Ribble Valley Borough Council

DELEGATED ITEM FILE REPORT - APPROVAL

Application No:	3/2015/0075/P
Development Proposed:	Two storey side extension and single storey rear extension.
Site Address:	21 Darkwood Crescent, Chatburn, BB7 4AL.

PROPOSED FIRST FLOOR PLAN  
SCALE 1:50

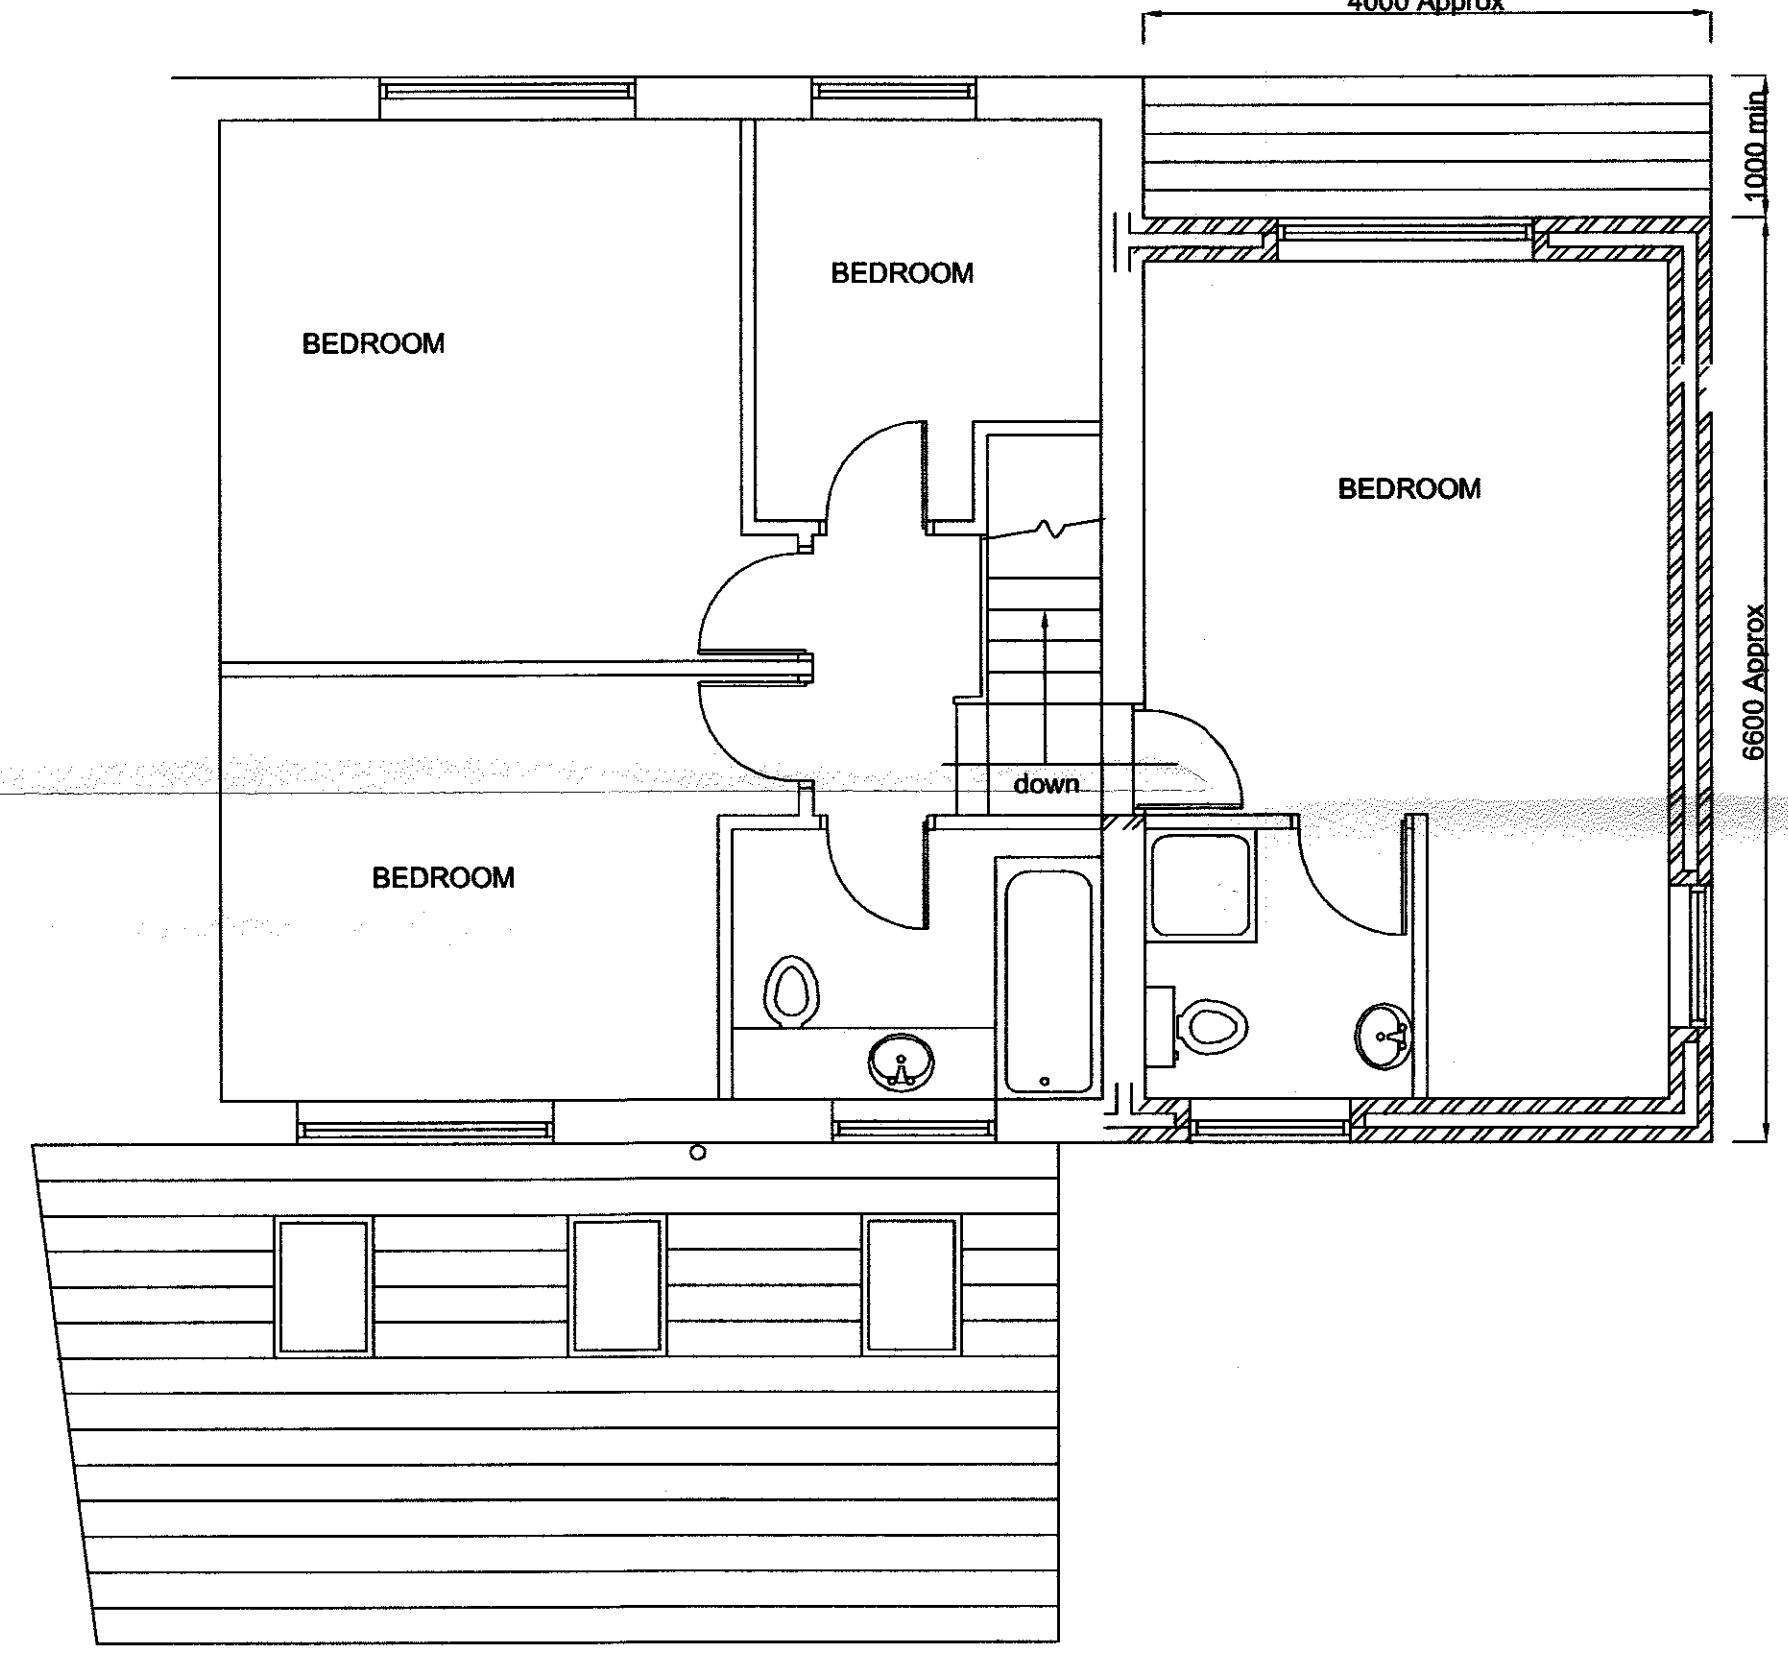
The ground floor of the two storey side extension would run flush with the front and rear elevations of the property and would accommodate a garage. The first floor portion would be set back from the principal elevation by 1.0m and would accommodate an additional bedroom, meaning the property would have four bedrooms.

PROPOSED REAR ELEVATION  
SCALE 1:100

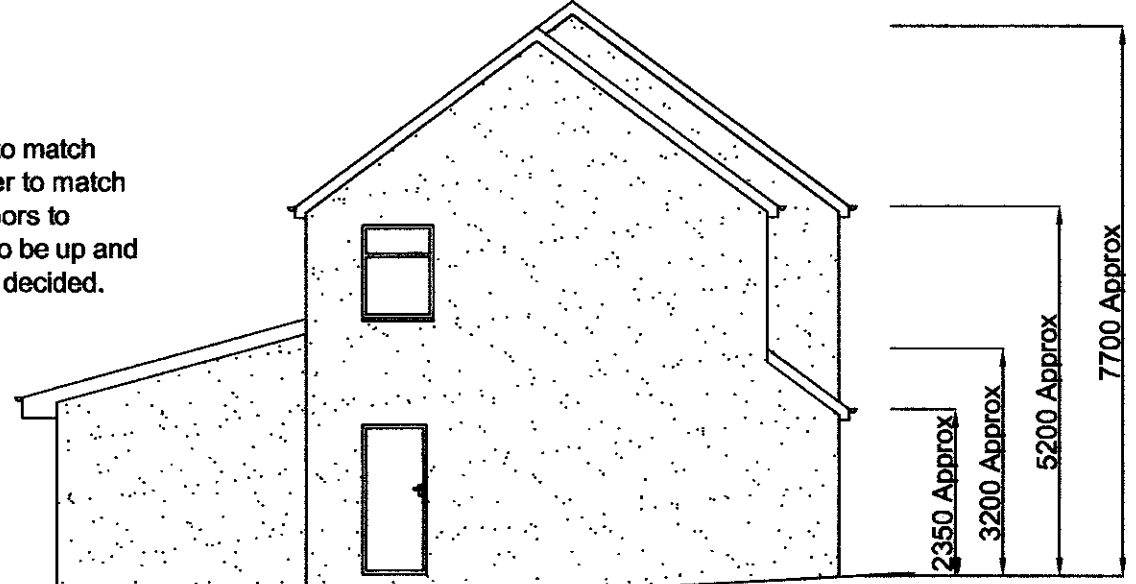
The ground floor extension proposed on the rear elevation would be positioned across the majority of the rear of the existing house giving it a width of 6.2m. The extension would project 3.5m from the rear elevation and would have a maximum height of approximately 3.5m.

The extensions will be rendered to match the existing property and would be roofed in concrete tiles to match the existing house.

In terms of residential amenity the proposals would also not adversely affect the amenities of nearby neighbours. The rear extension would abut a similar single storey rear extension on the rear of the adjoining dwelling, no. 23 Darkwood Crescent, therefore no loss of light or overshadowing of this neighbouring dwelling will occur.
